Martin Nugent
01254 828060
D3/12/0888

Drafted 23 November 2012

**Planning Application, Ribble Valley District
3/12/0888 142 Woone Lane, Clitheroe**

PROPOSED GROUND FLOOR PLAN
Scale :: 1:150

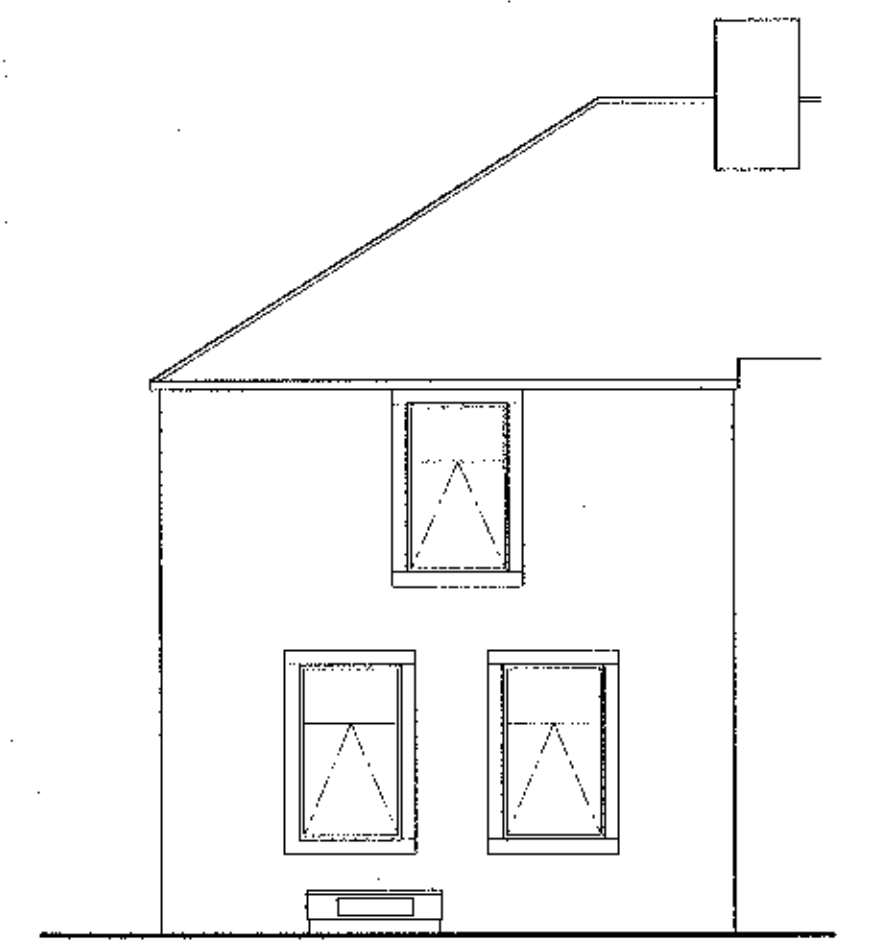
I have no concerns with the proposed alterations to the pedestrian access arrangements for this property and recognise that they will be of considerable benefit to the resident.

However, the changes being made on the Kay Street gable side of this property will require an alteration to the existing drop kerbs. The construction and maintenance of this feature must be completed in accordance with a scheme to be agreed by the Local Planning Authority in conjunction with the Highway Authority.
